Appeal Decision

Appeal Ref: APP/R5510/D/23/3319518

41 Grange Road, Hayes, Hillingdon UB3 2RP

- The appeal is made under section 78 of the Town and Country Planning Act 1990 against a refusal to grant planning permission.
- The appeal is made by Mr Darshan Singh against the decision of the London Borough of Hillingdon.
- The application Ref.19772/APP/2023/80, dated 10 January 2023, was refused by notice dated 7 March 2023.
- The development proposed is the "Use of outbuilding at the rear of garden as a habitable room for guests."

DRAWING TITLE:  
PROPOSED GROUND  
FLOOR PLAN

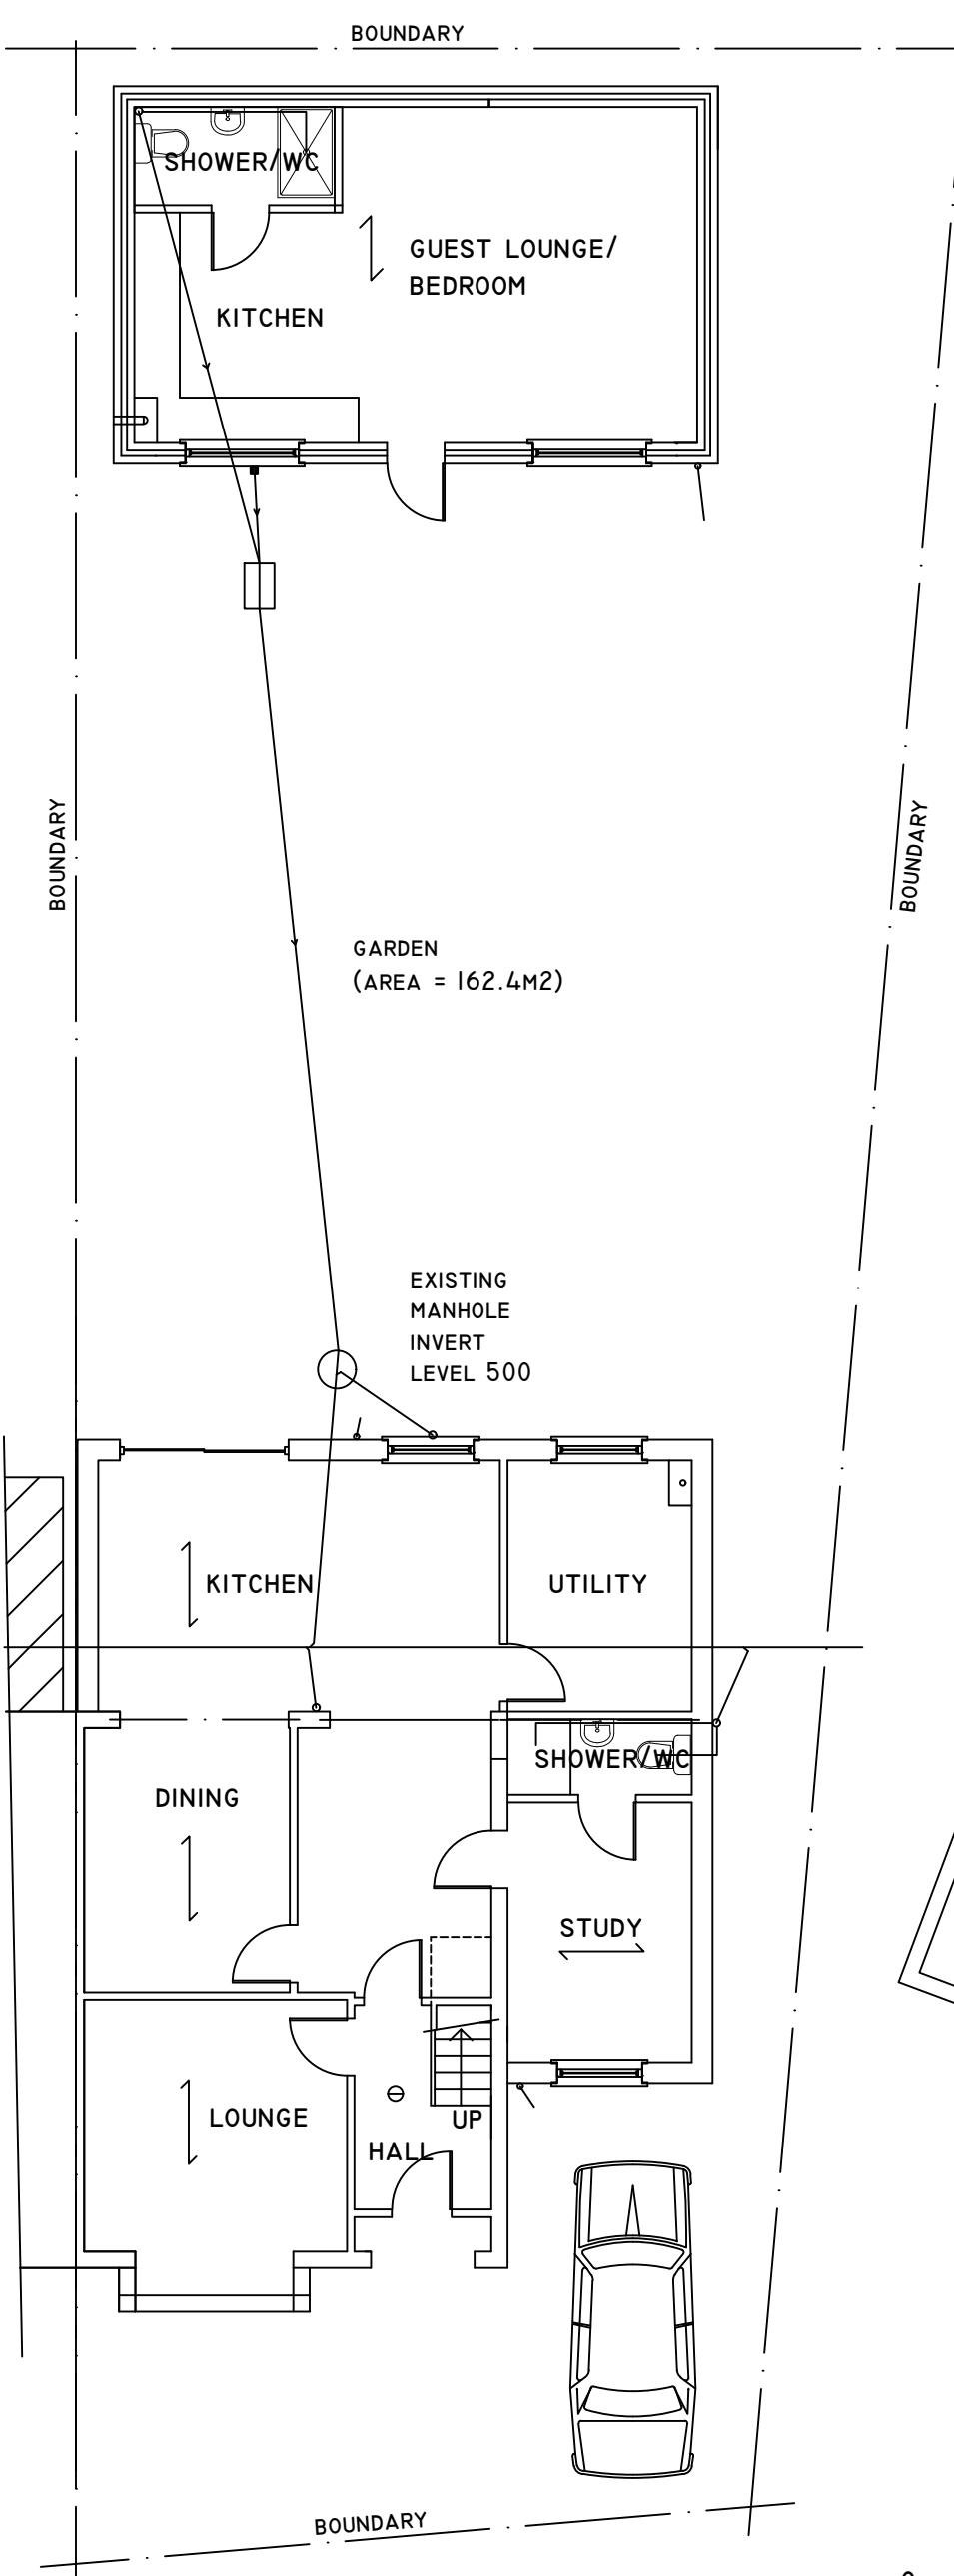
The internal floor area would be approximately 40 sqm. The submitted plans show an L-shaped kitchen area within the main room (annotated as a guest lounge and bedroom) and a separate WC and shower room. A key question is whether what is being proposed would have the distinctive characteristics of a dwellinghouse such that it would comprise a self-contained separate residential unit. It is established through case law that the distinctive characteristic of a dwellinghouse is its ability to afford to those who use it the facilities required for day-to-day private domestic existence (see *Gravesham Borough Council v. Secretary of State for the Environment* (1984) 47 P & CR 142). Furthermore, the Housing Act 2004 implies that a separate unit for independent occupation would need the basic amenities of a toilet, personal washing facilities and cooking facilities.

6. What is proposed in the outbuilding in this appeal would provide a potential occupier with the basic amenities for day-to-day private domestic existence. He or she would not need to access the main house in order to achieve a day-to-day existence in the outbuilding. Furthermore, access to the outbuilding would not be dependent on walking through the inside of the main house.

DRAWING TITLE:  
EXISTING / PROPOSED  
ELEVATIONS

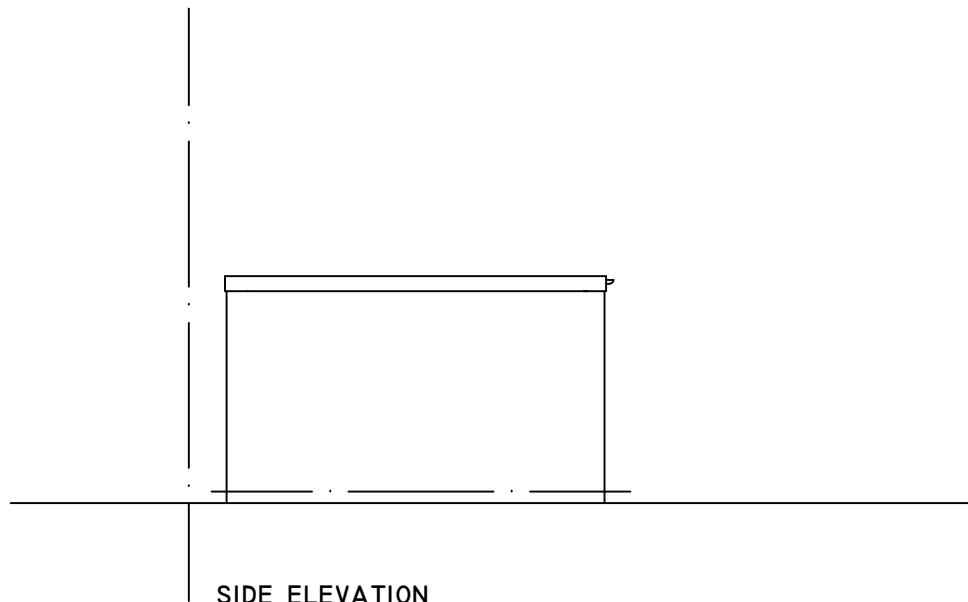
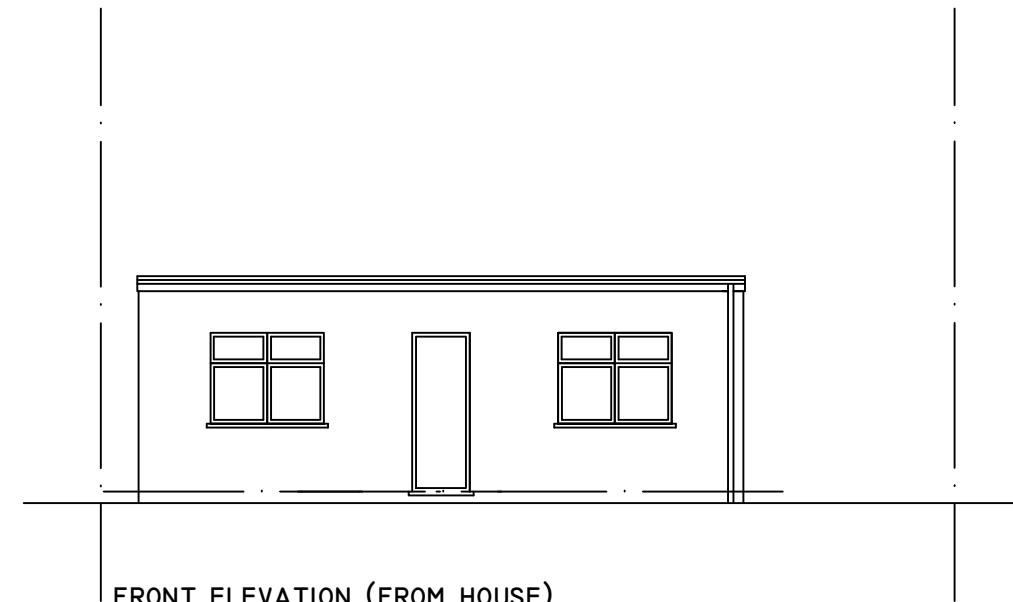
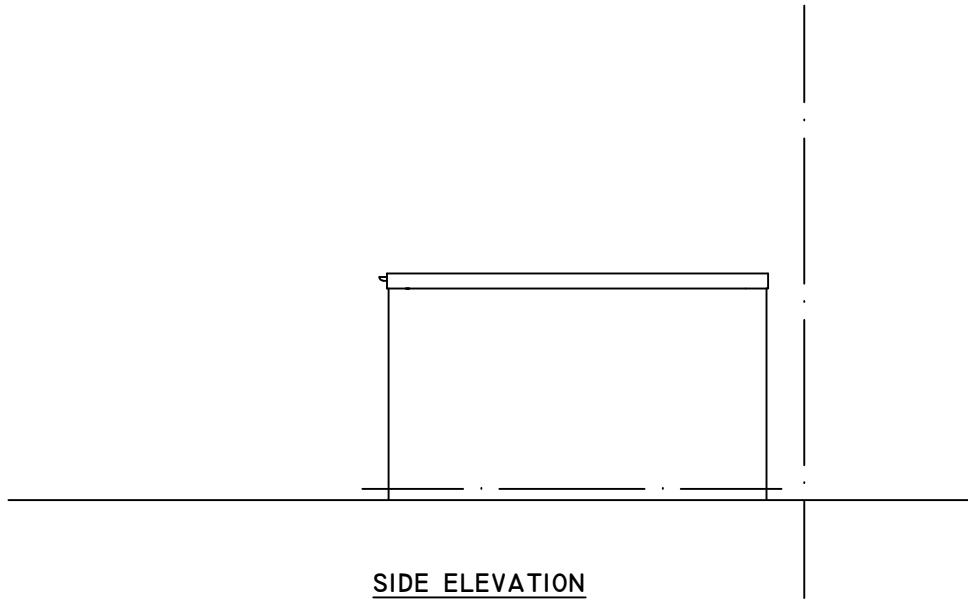
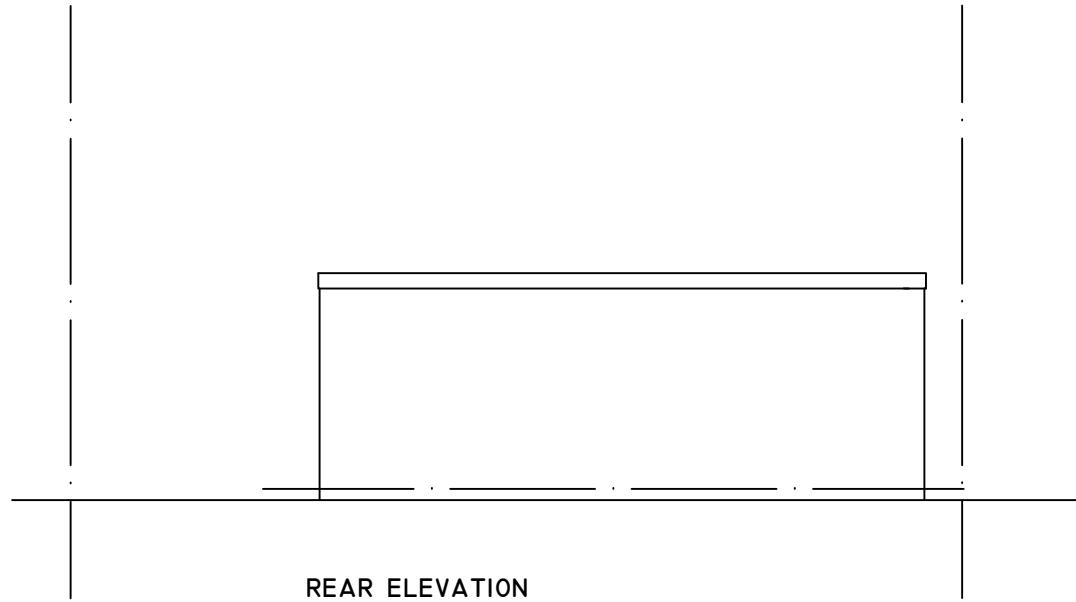
12. The windows in the front elevation of the outbuilding would be overlooked from the rear windows of no.41 Grange Road such that the privacy of the future occupants would be unduly compromised, and similarly, the privacy of the occupants of no.41 would be compromised by overlooking from the residential occupants of the outbuilding. Furthermore, I am concerned that the rear garden of no.41 could not provide adequate private amenity space for two self-contained residential units (i.e. no.41 and the proposed development as a self-contained new home).
